Your ref: AL/8/18/PL

26th February 2018

Erection of 2 No.2 bedroom dwellings with associated parking & landscaping.
Land between 8 & 10 Barnett Close Eastergate

Figure: Site Location Plan (aerial image and red site boundary line for indicative purposes only)

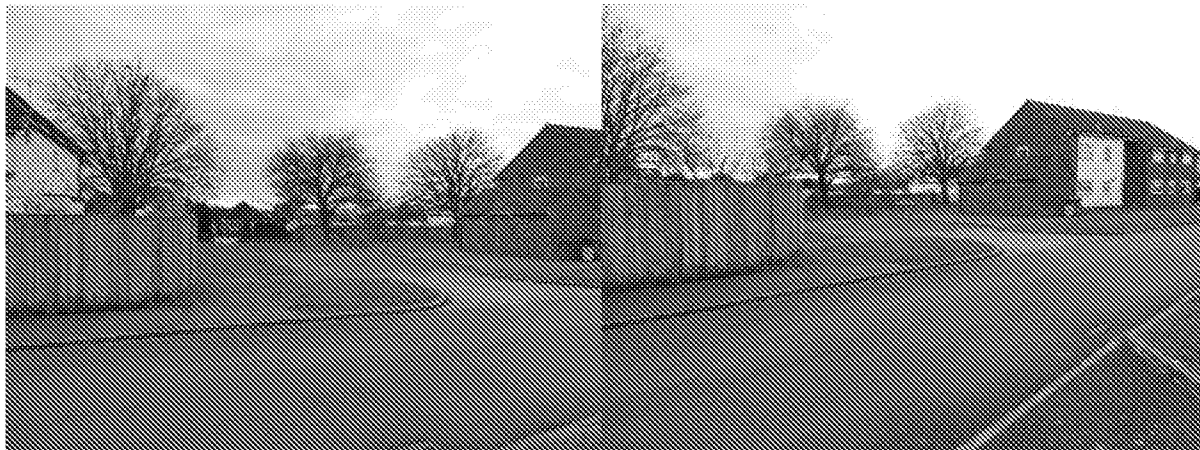
On page two of the planning application/design and access statement, the picture of only one car parked on the proposed development area, is an image lifted from Google Earth dated March 2009, the car a Toyota Corolla belonged to former residents of number 33 who moved from the Close in 2012. (flawed evidence)
